**Subject:** Cleve Hill Solar Park EN010085 Ref 20018862

Cleve Hill Solar Park – Soil and agricultural Use Classification– Objections - Addendum Summary

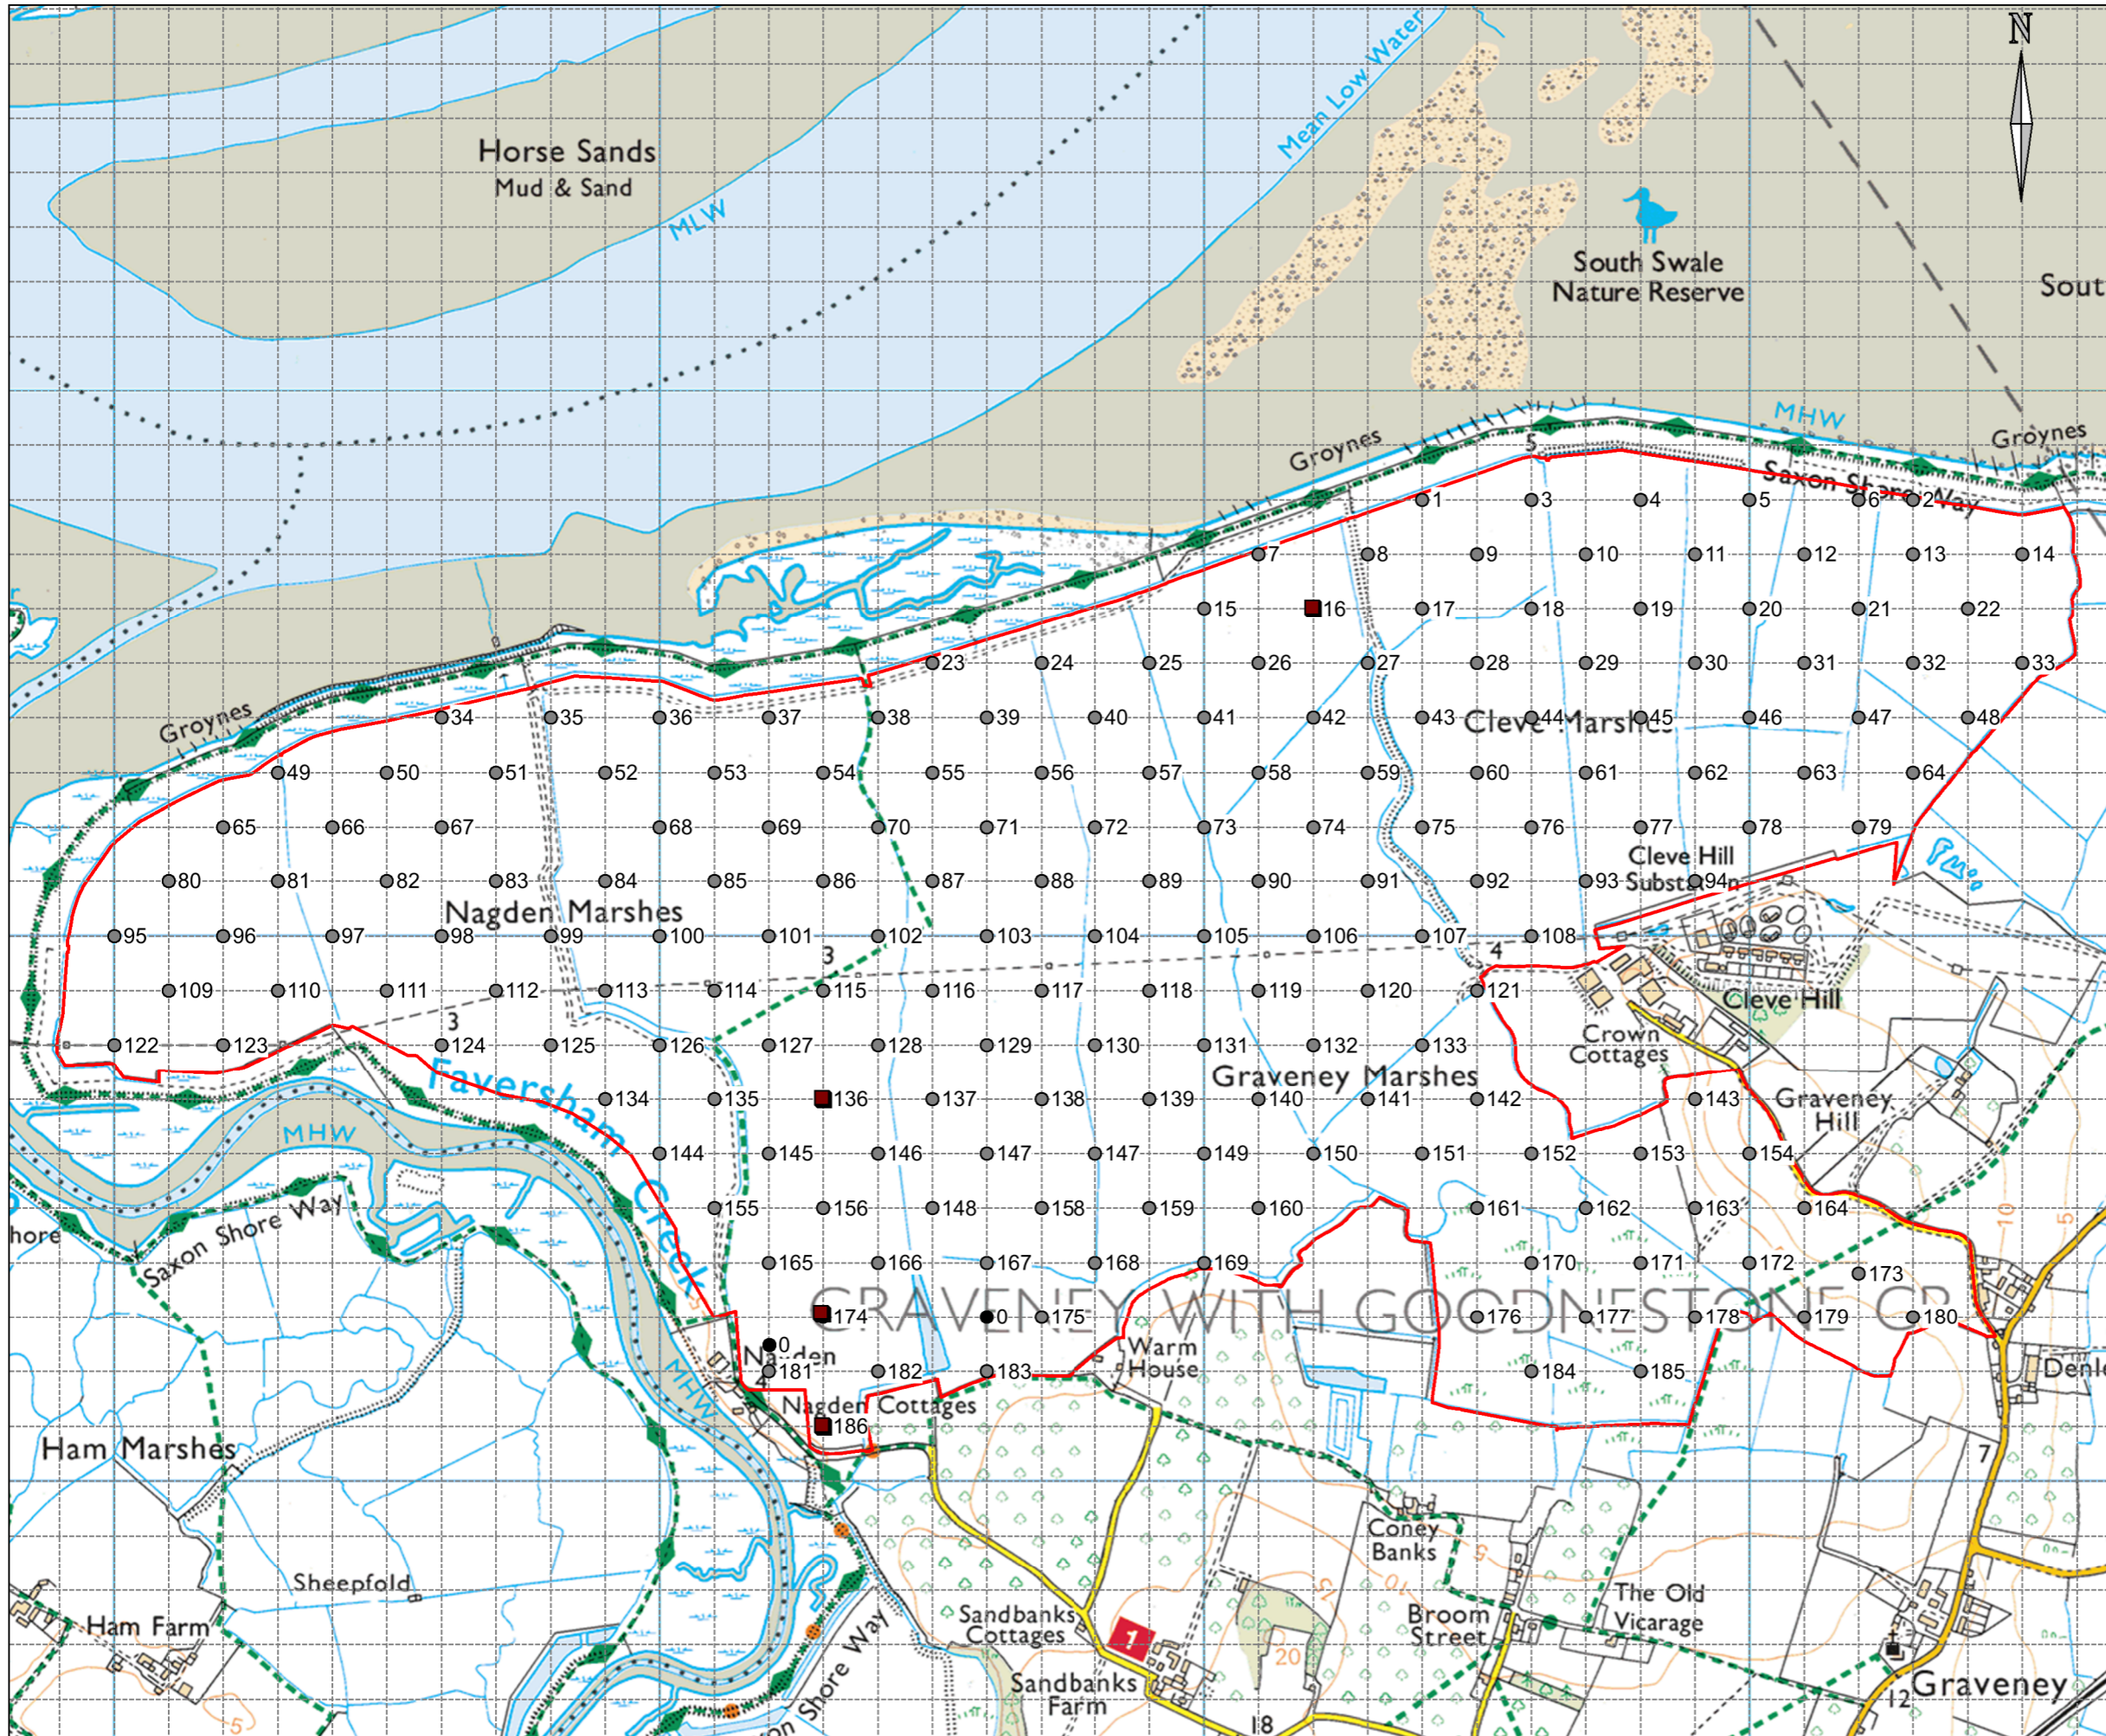
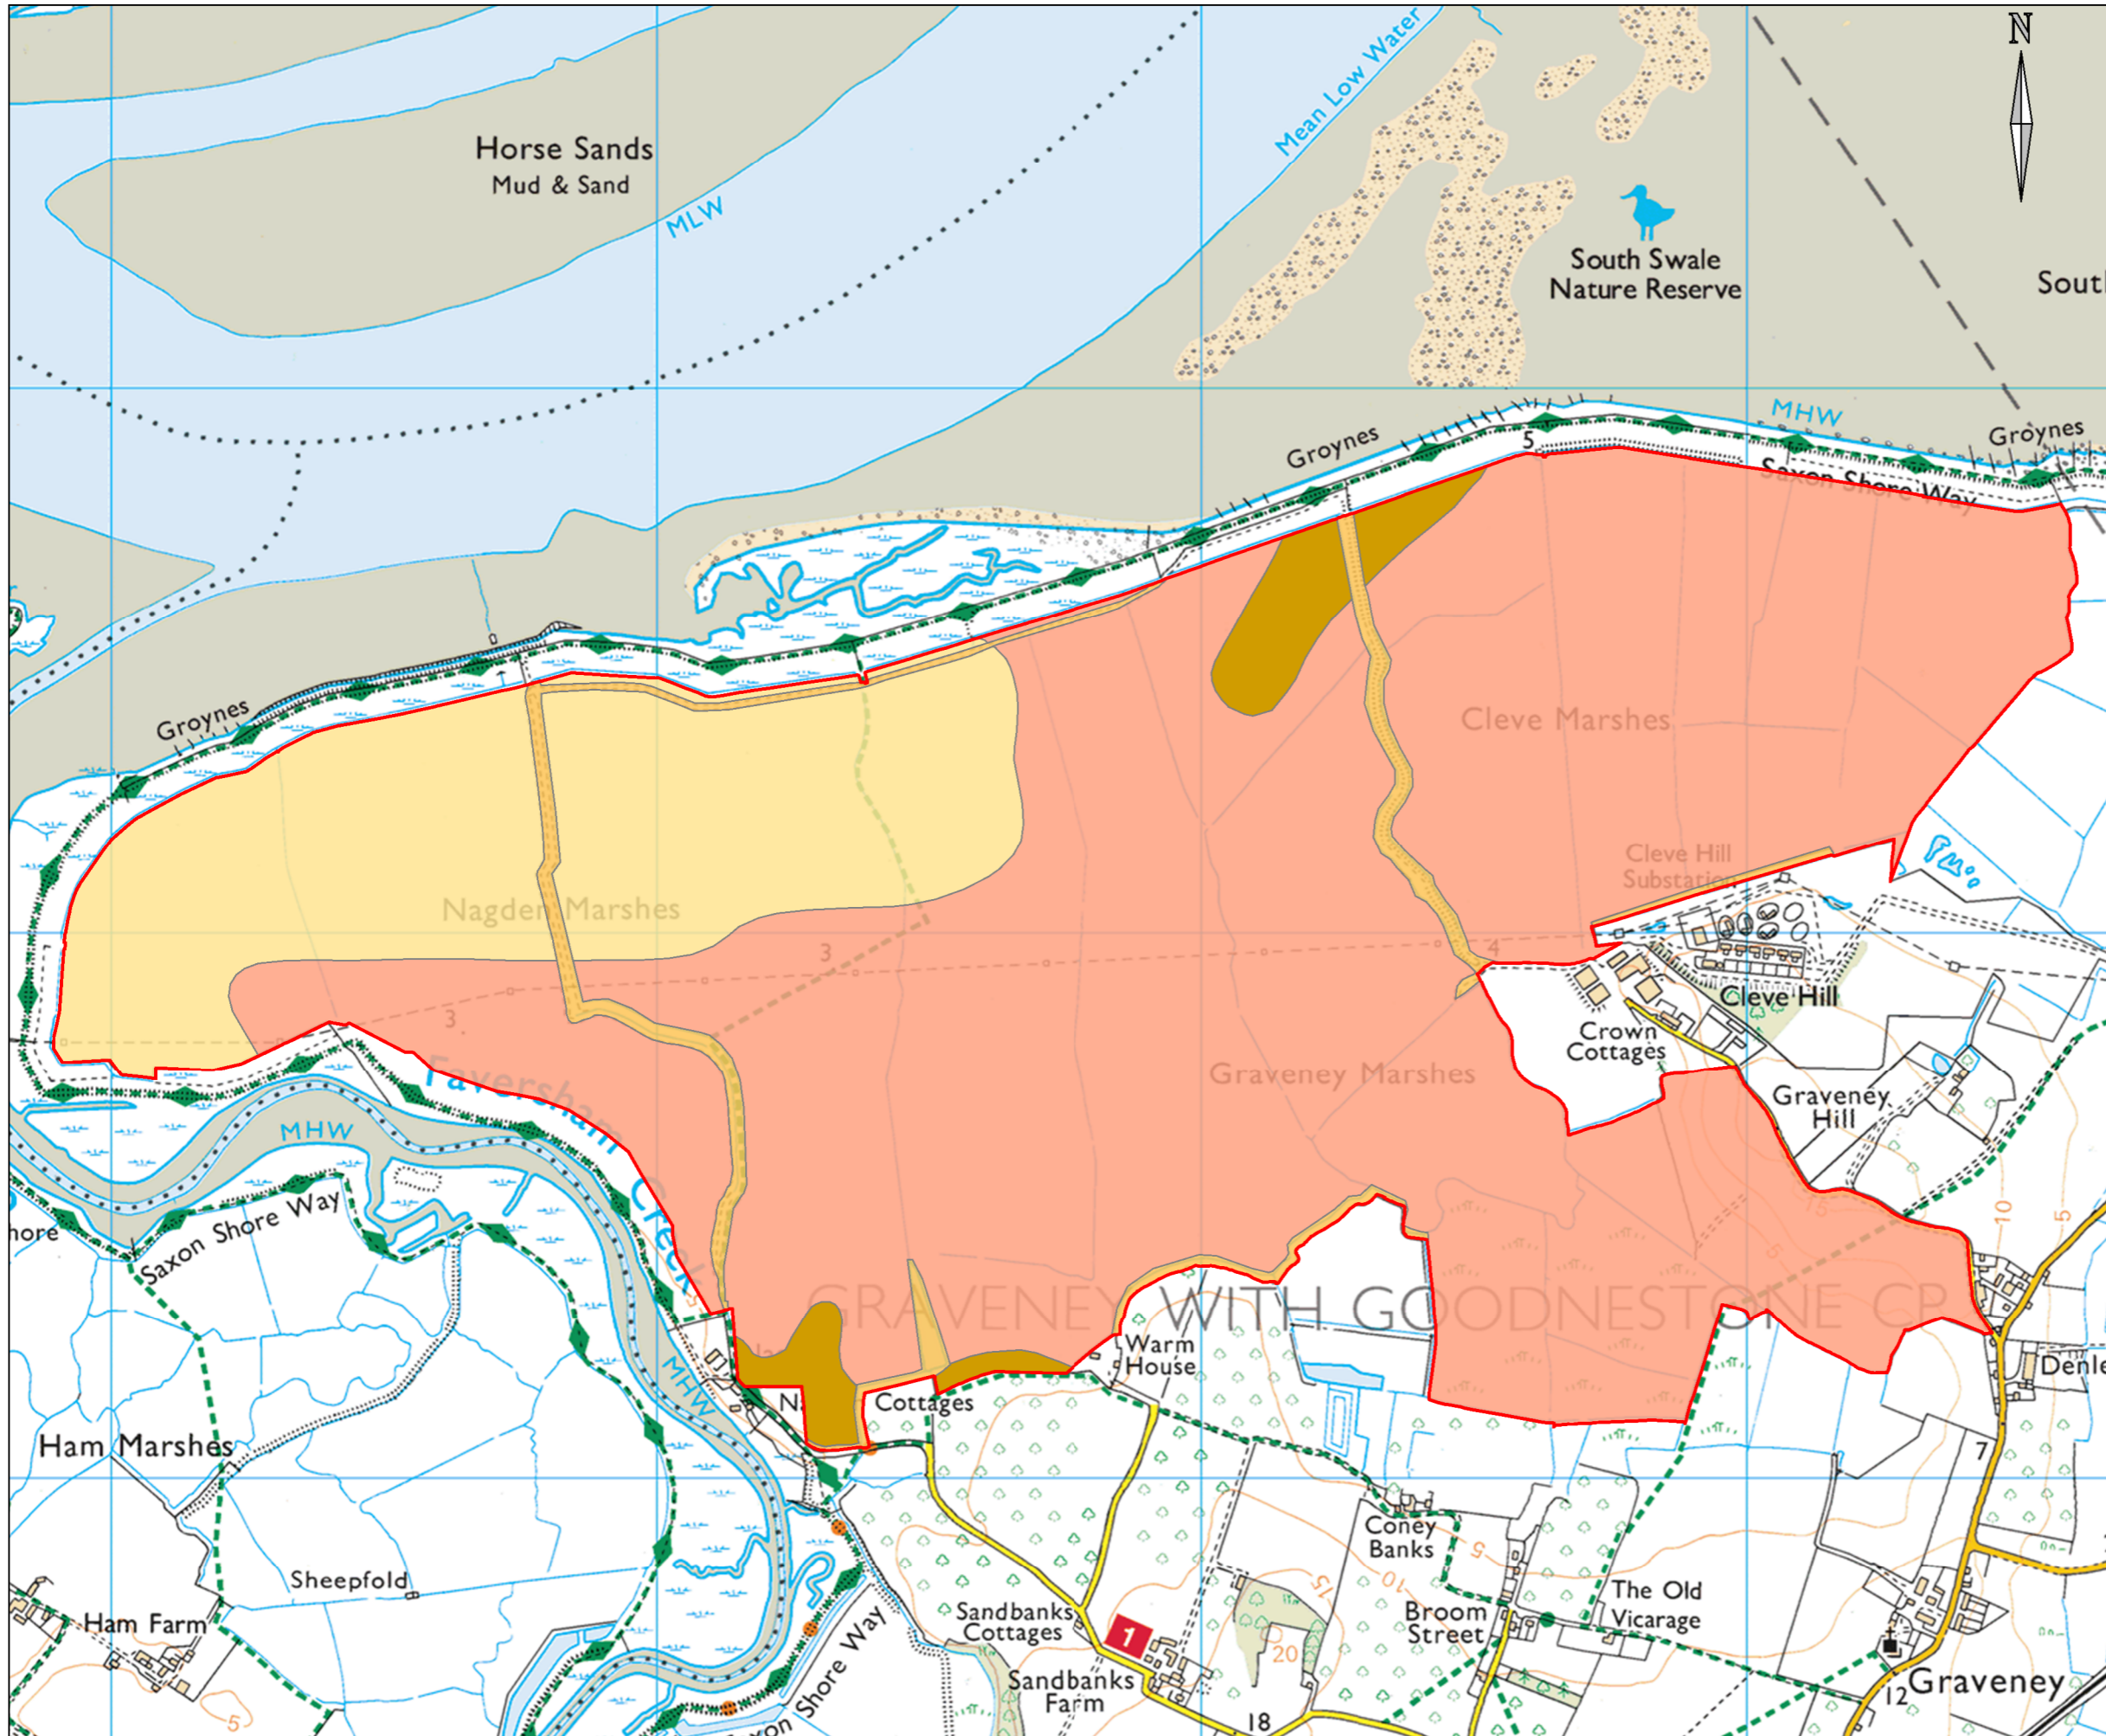
- The Cleve Hill Solar Park SALU 2017 report does not follow and meet the standards of assessment detailed in the ALC MAFF 1988 guidelines;
- The field survey is ‘biased’ in relation to being undertaken at the time of year following an extremely wet February 2017 followed by two weeks of rainfall during the duration of the field survey at the beginning of March 2017;

- Incomplete data has been presented in the report submitted to The Planning Inspectorate;
- Some assessment criteria to determine Wetness Class for two observation locations have been incorrectly interpreted;

- A large number of observation points have been entirely incorrectly interpreted based on the presence of naturally calcareous clay soils;
- No quantitative data (as defined by the MAFF 1988 guidelines) has been presented in the report demonstrating that the soils at the site are water logged for the duration of more than 91-180 days ‘for most years’ i.e Wetness Class III;

- The Soil Survey Handbook 1979, which forms part of the MAFF 1988 guidelines details that single observations at one particular time are speculative and very subjective and also details that soil profiles should not normally be allocated to Class II, III and IV using a single survey at one particular time.

- The gradient of land was identified in the Cleve Hill Solar Park SALUQ 2017 report as a limiting factor, but no actual data was presented to corroborate this statement, and in fact the only

on-site data presented in the Cleve Hill Solar Park SALUQ 2017 report and compared to MAFF 1998 guideline indicates that land with slopes less than 7° are considered Grade 1, Grade 2 or Subgrade 3a land.

- Re-evaluation of the Wetness Class across the site, based on actual and local metrological data and considering that a large part of the land has naturally calcareous soils, it is my opinion that over 75% of the land at Cleve Hill Farm can be graded as Grade 2 (very good agricultural land) and Subgrade 3a (good agricultural land) in accordance with MAFF 1988 guidelines.
